From: lesley lund <lesleylnd@gmail.com>
Sent: 18 February 2016 22:25
To: planning
Subject: Comments on Planning Applicaitons

3/2016/0083 Dunsley 160 Whalley Road Wilpshire

Rear Elevation (Facing South East - Fronting Garden)

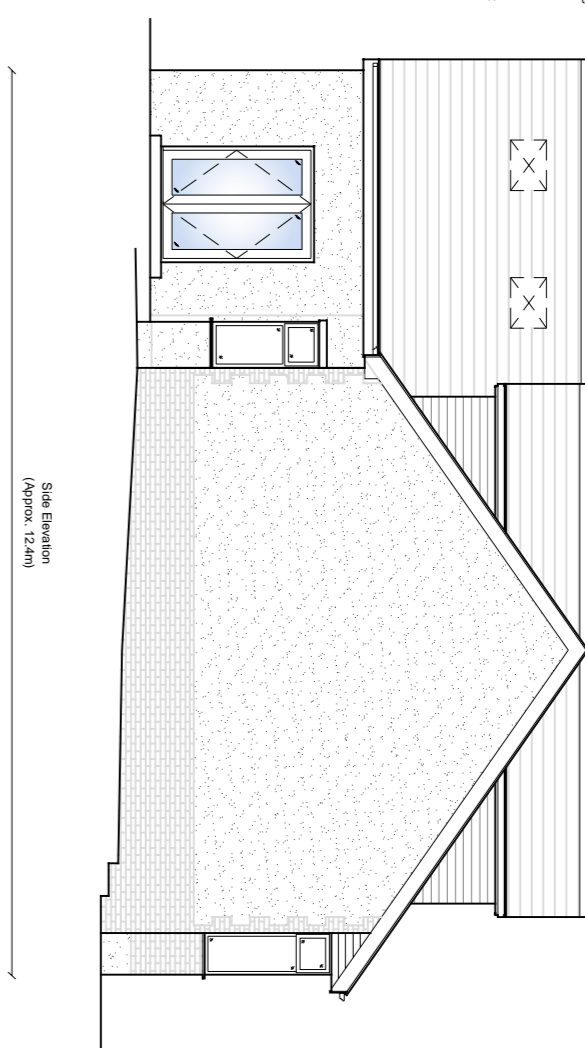
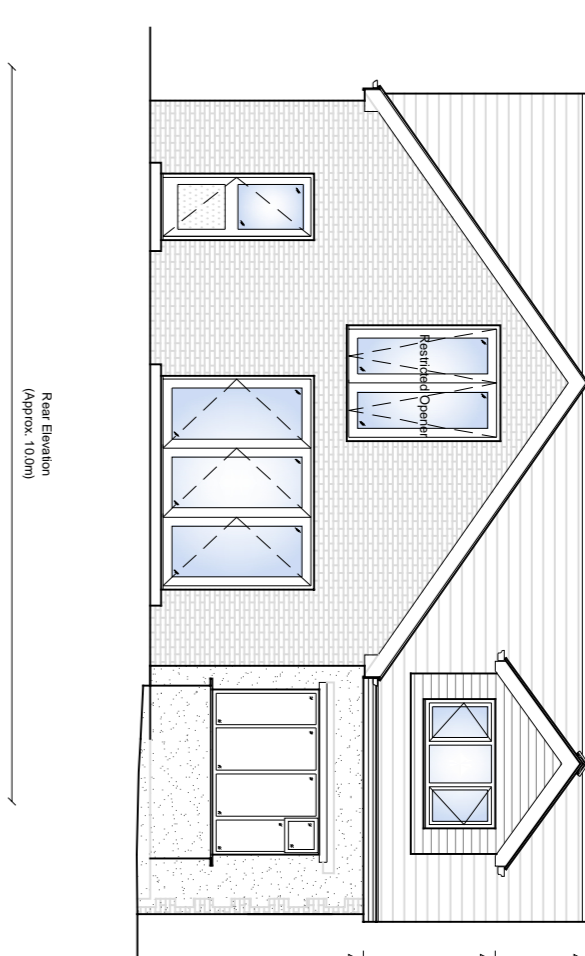
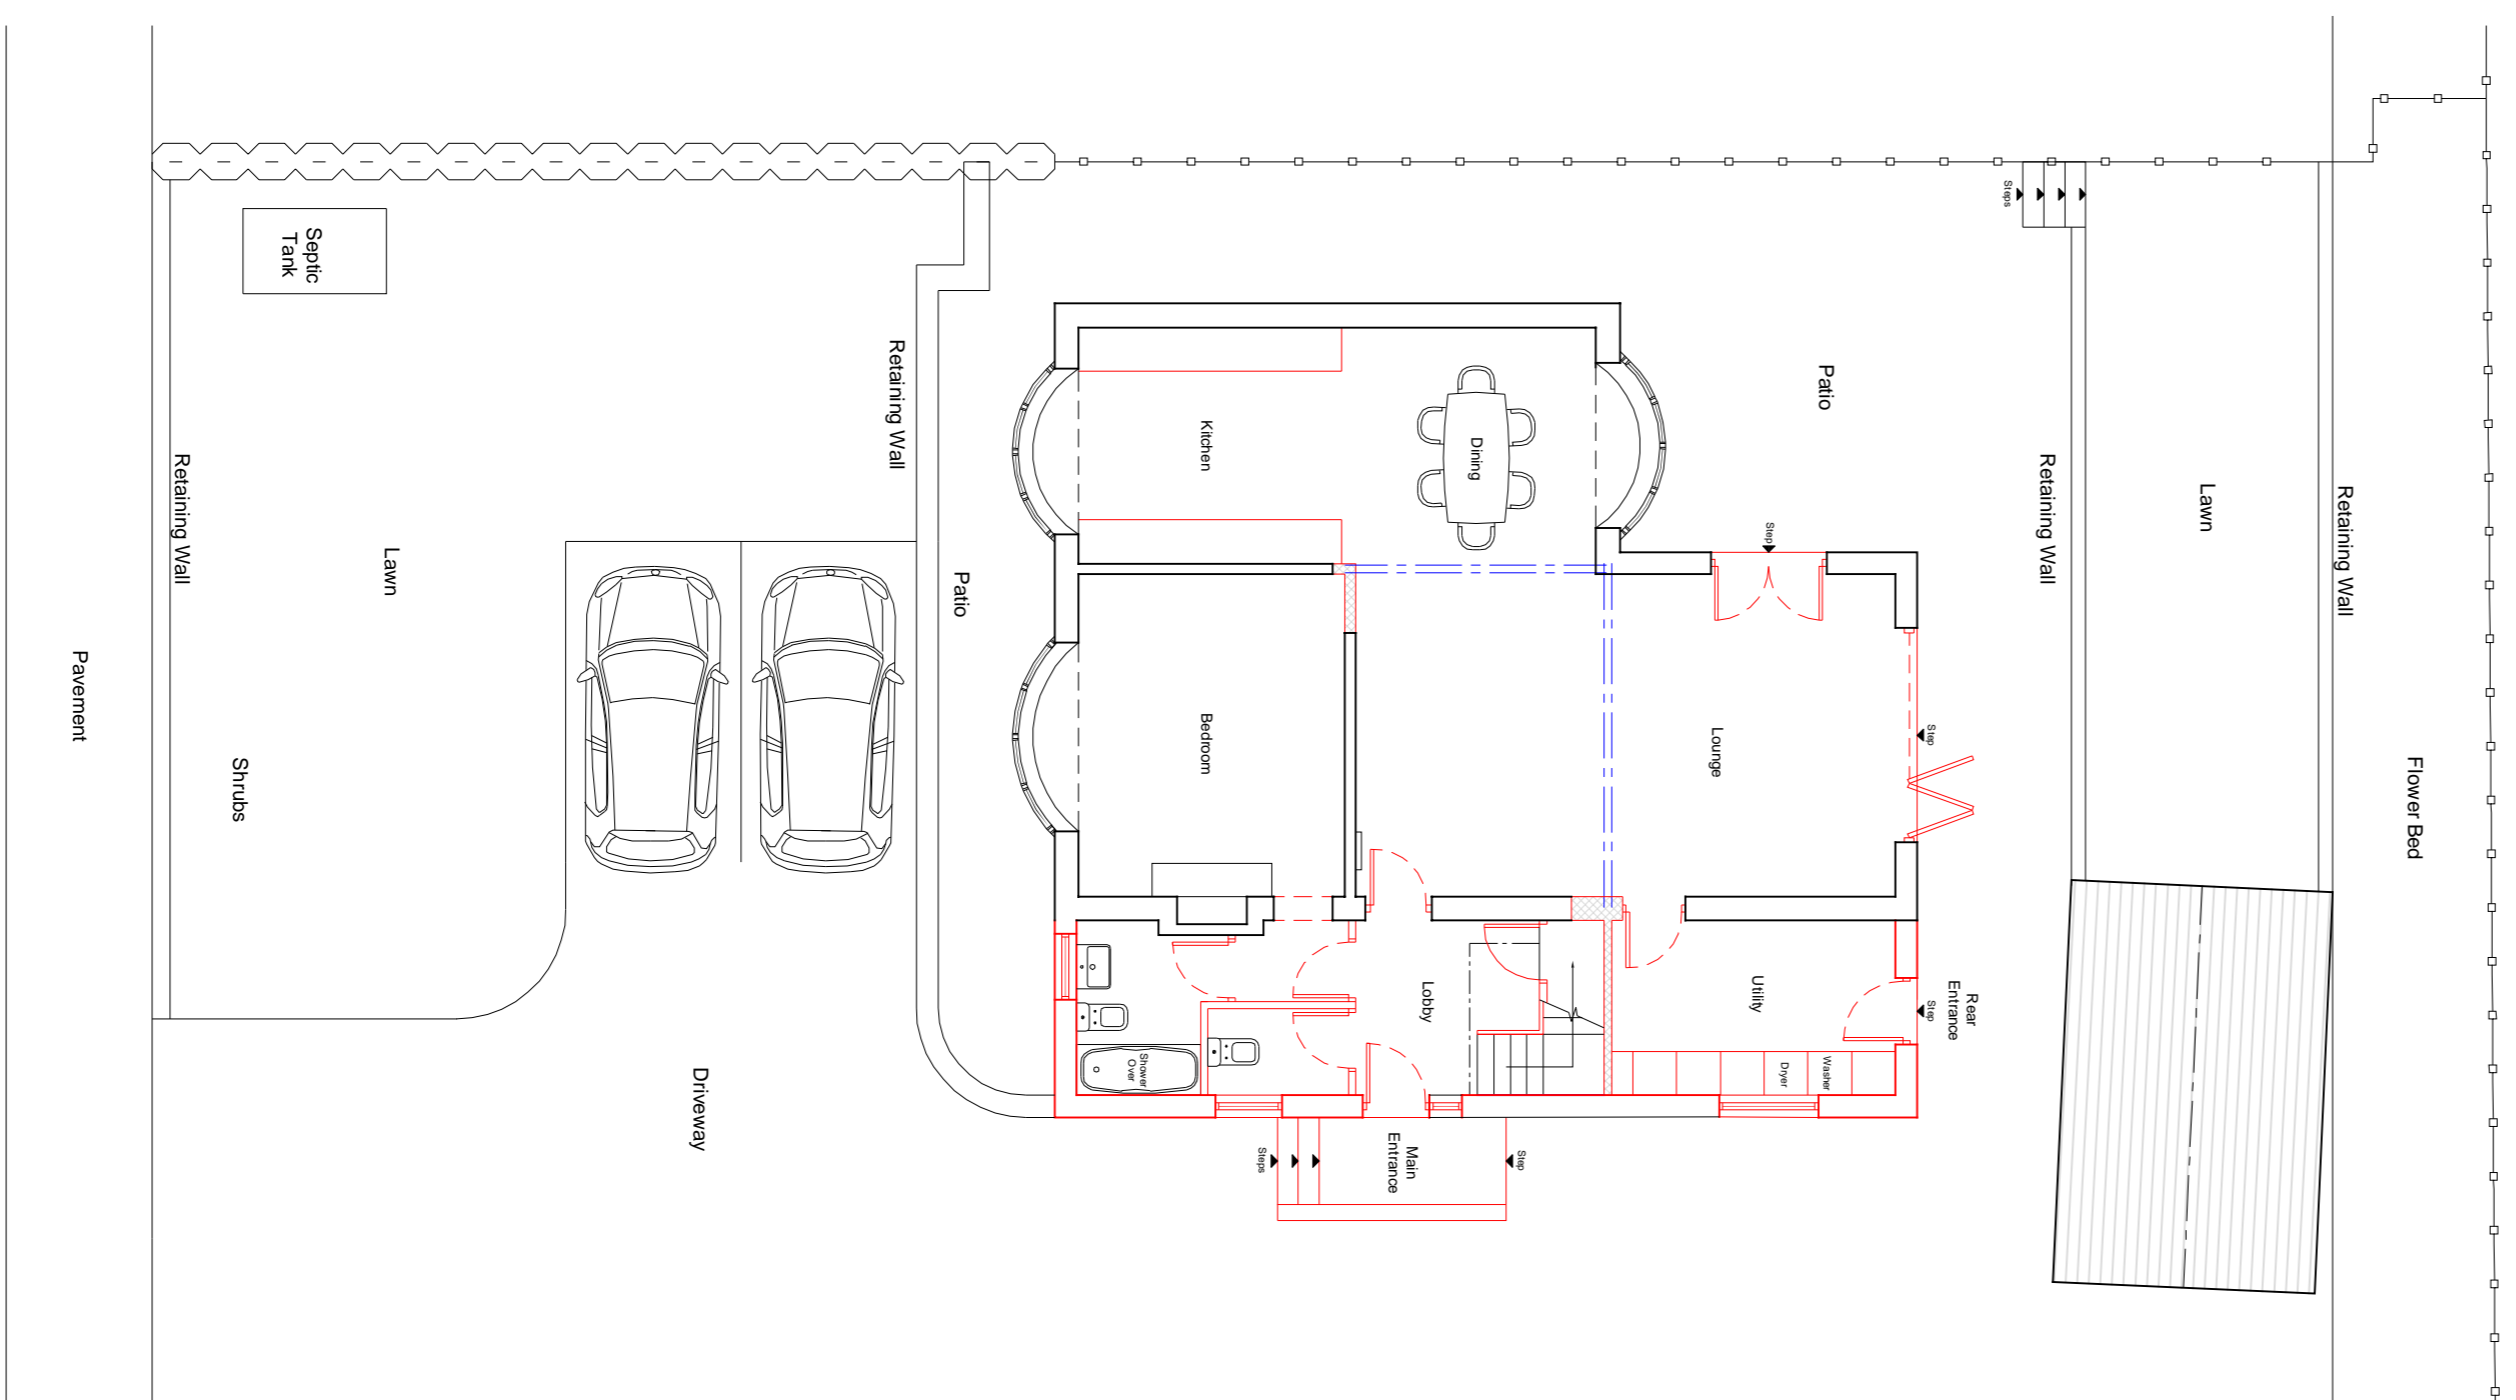
WPC have concerns about overlook from the dormer in the rear bedroom. It is in the SE (side) elevation and would have a direct overlook to the neighbour.

DRAWING TITLE:
 Proposed Site Plan

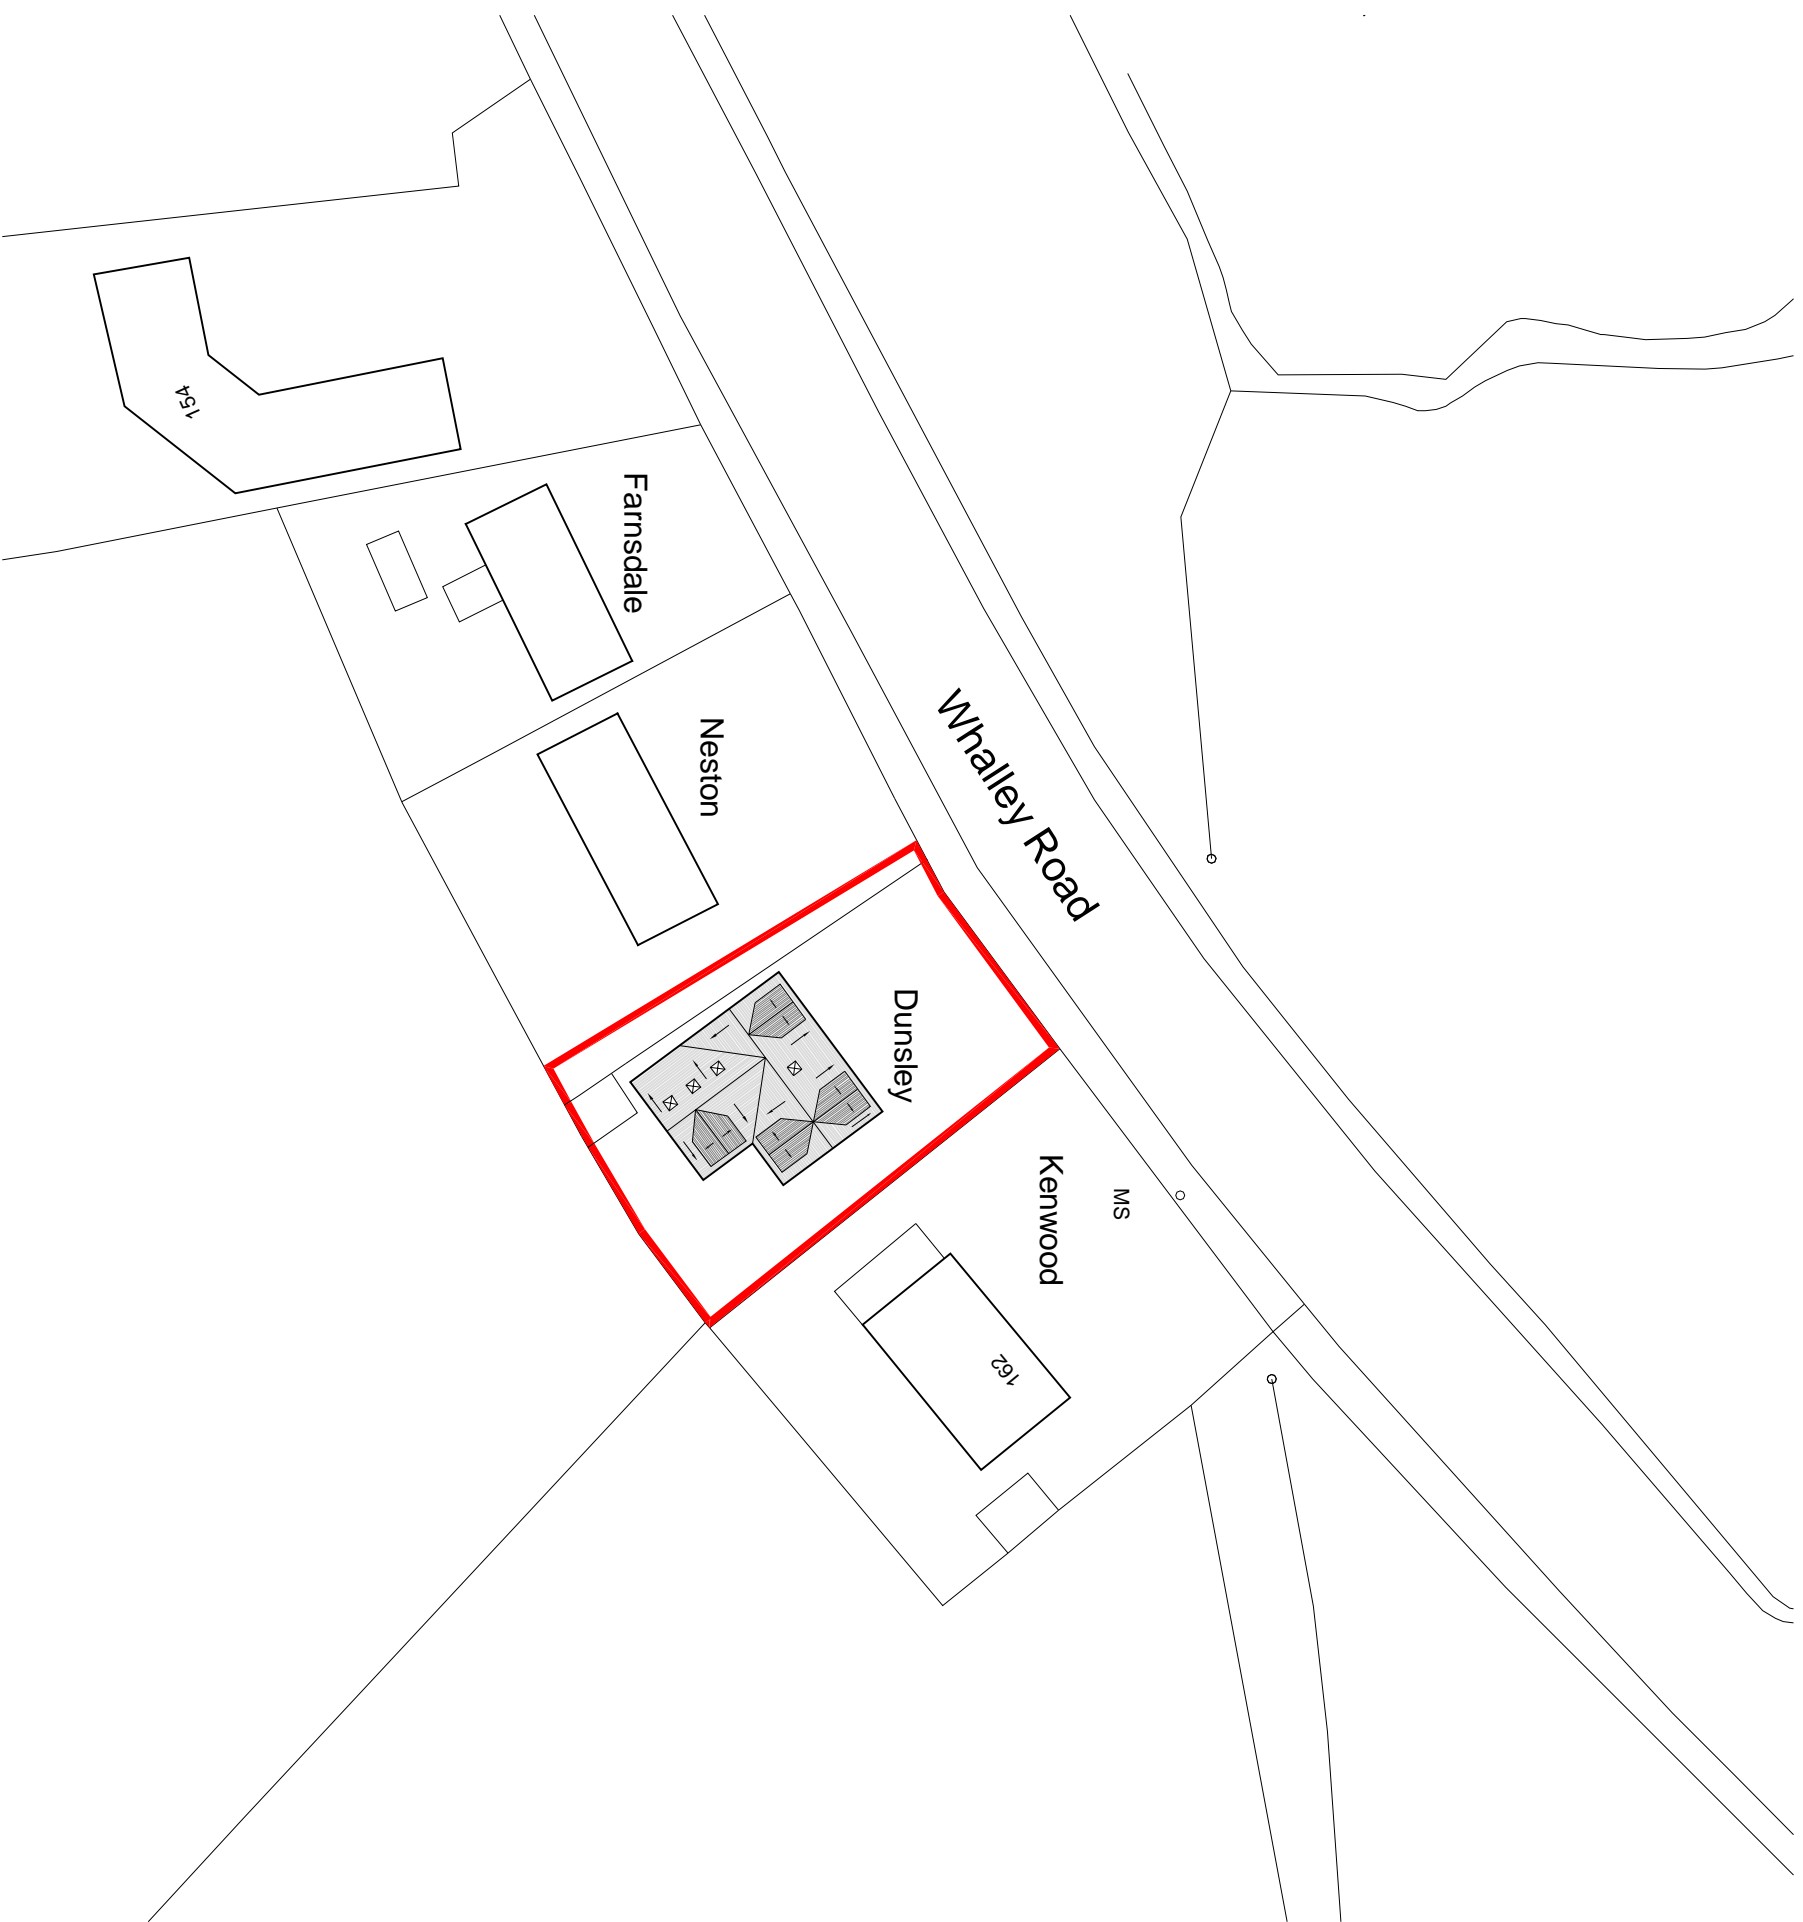
There is also concern that the space left at the rear is insufficient for a 4 bed family home in this area.
